## SHORT STOP – PHOTOMETRIC LIGHTING PLAN VARIANCE REQUEST

VARIANCE REQUEST: It is requested that the requirement for a photometric plan be waived for this project.

SD-3

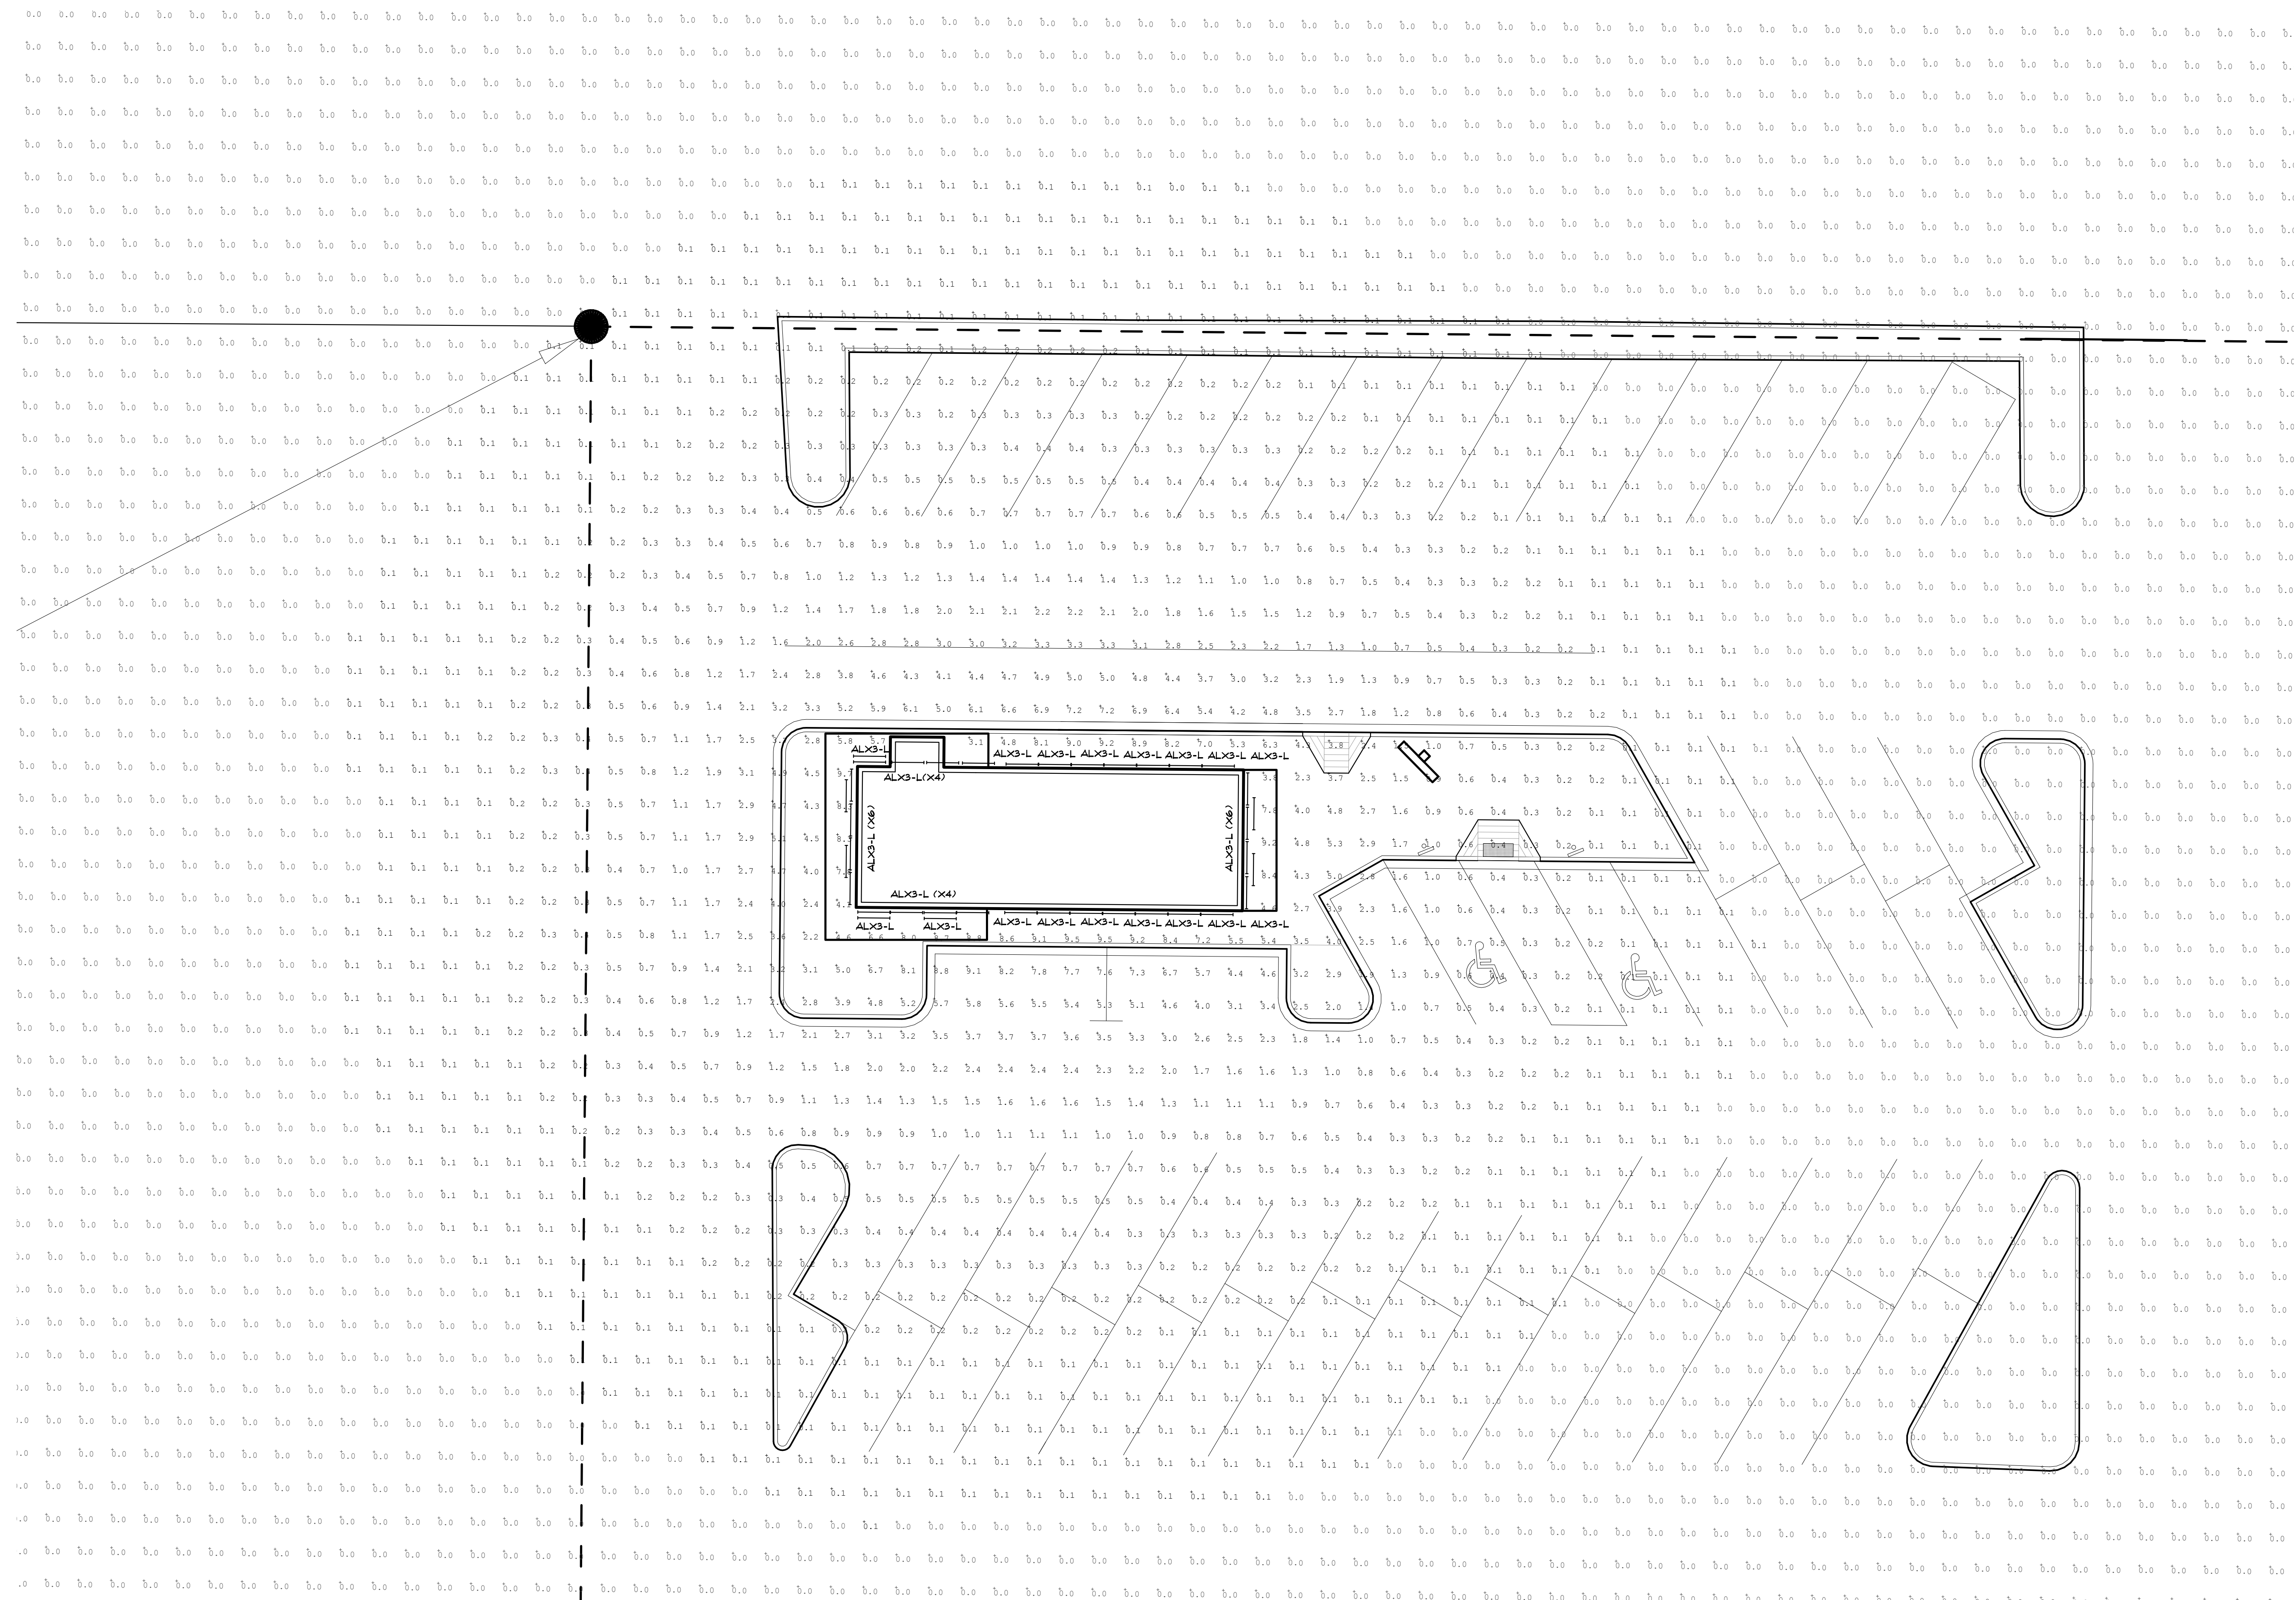
If there are lights being proposed you will need a photometric, or at least a detail on what type of lights are being attached to the building. You can request an alternative lighting request which is found in Ch. 6 section 6.2.3.E. but we will still need to see something verifying your lighting is allowable.
